Revise to:
"PPR2311"
(with no dashes or extras zeros or
extra spaces in the file number)

EL PASO COUNTY GRADING AND EROSION CONTROL PLAN CHECKLIST

File: 0:\1805A-CRMUR-L01\1\The Equity Group\Drawings\Const Dwg\Grading\LOT 2\GR01-GR02.dwg Plotstamp: 9/14/2023 4:09 PM

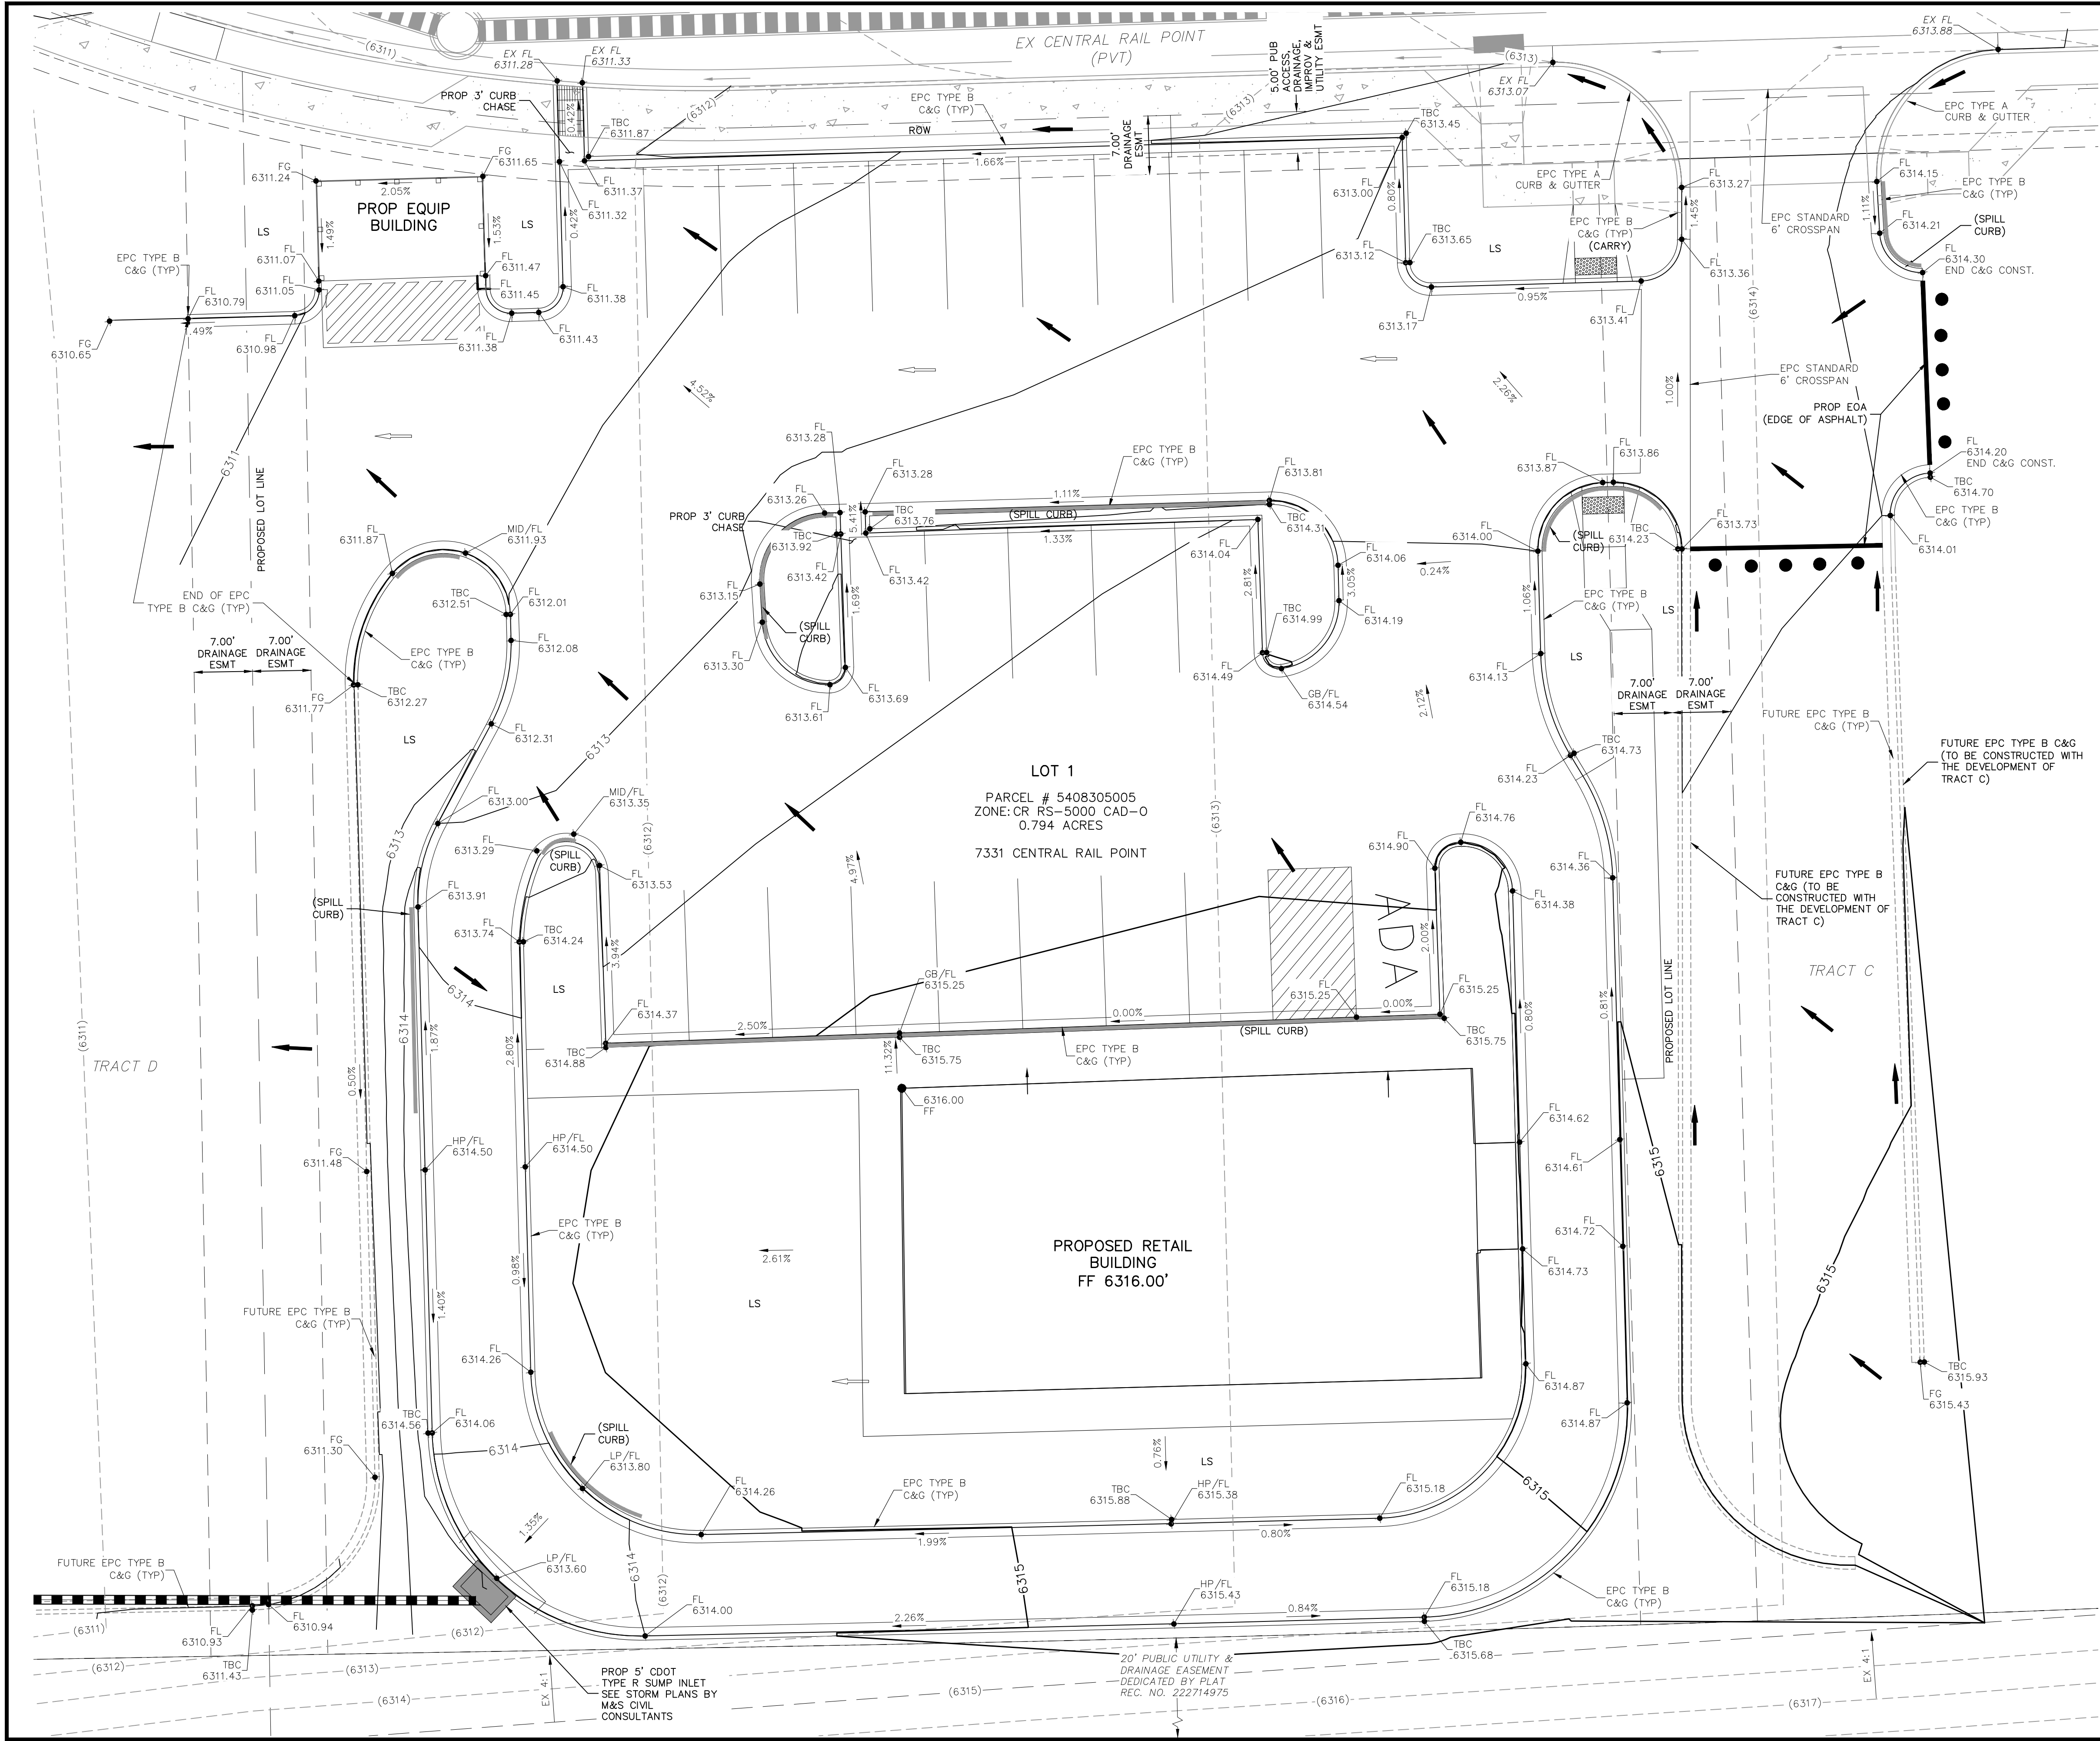
w	Vehicle tracking provided at all construction entrances/exits. Construction fencing, barricades, and/or signage provided at access points not to be used for construction		N
x	Temporary sediment ponds provided for disturbed drainage areas greater than 1 acre		Y

See my comment on Sht GEC02 of GEC Plans

THE VTC HAS BEEN REVISED FOR FILING NO.2 AND FILING NO.2 LOT 2 ONLY. NO CHANGES WILL BE MADE FOR FILING NO.1 SINCE IT IS ASSUMED THAT THE SOUTHERN RAIL POINT WILL ALREADY HAVE BEEN BUILT AT THE START OF FILING NO.2 LOT 2 CONSTRUCTION. A TYPE 3 CONSTRUCTION BARRICADE HAS ALSO BEEN ADDED IN ORDER TO PREVENT USE OF EAST EXIT DURING LOT 2 CONSTRUCTION.
